Our ref: DOC20/633938

Senders ref: SSD 9835 MOD 2(City of Sydney)

**Subject: Modification 2 Application to modify State Significant Development (SSD) Consent 9835 relating to the Stage 2 detailed design, construction and operation of the Sydney Football Stadium, 40-44 Driver Avenue, Moore Park.**

EES have reviewed the Modification Report prepared by Ethos Urban dated 31 July 2020 and make the following comments.

Figure 4: Hydraulic Model Layout - Proposed Case Scenario DES17

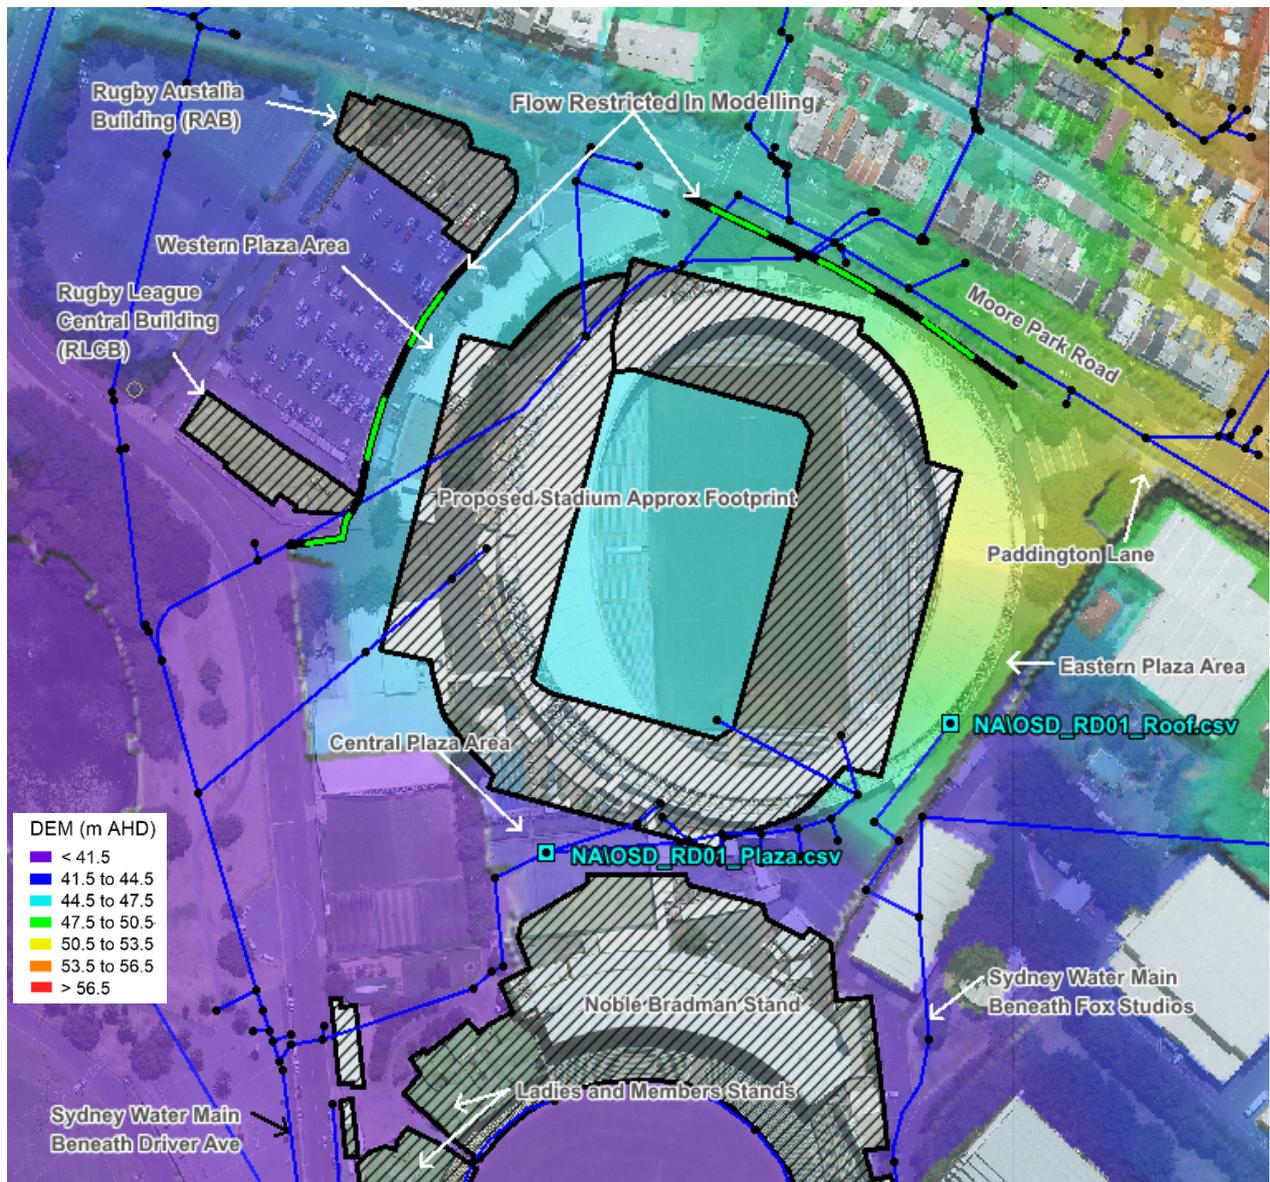
- Post development scenario flood modelling is required but has not been completed. This is required for the purpose of determining local flood levels that will dictate finished floor levels of the fitness facilities.

- Proposed changes to trunk drainage have not been modelled but it needs to be demonstrated that these do not have an impact on flooding conditions. Similarly, the resultant flood levels are required to inform floor levels.

Figure 10: Stadium Catchment Plan

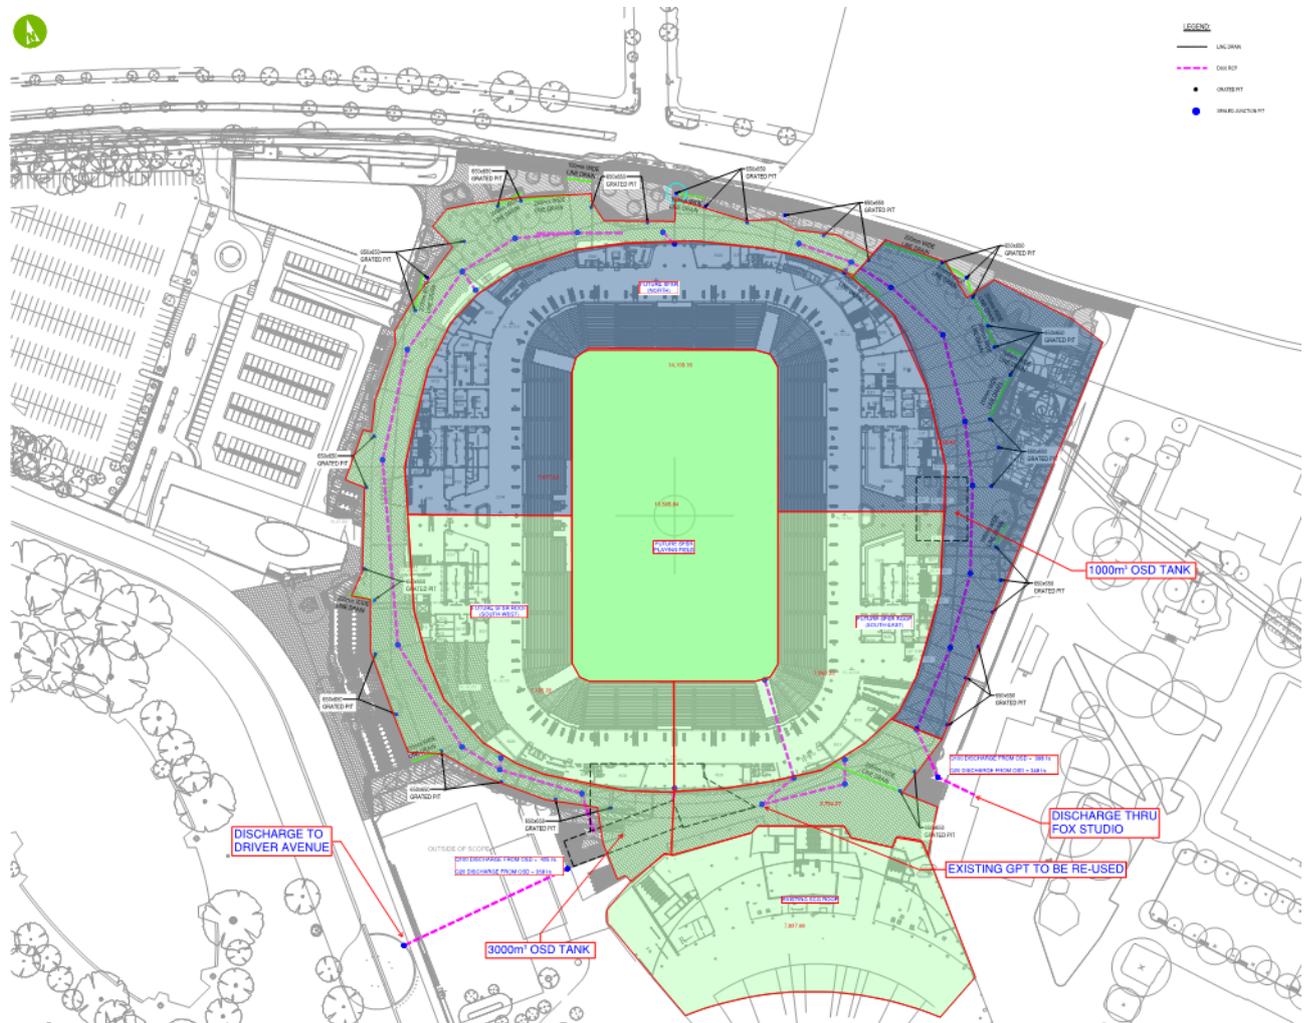
- Onsite detention tank needs to be resized for new development for proof of concept given that the works are already under construction and the ability to make modifications is compromised.
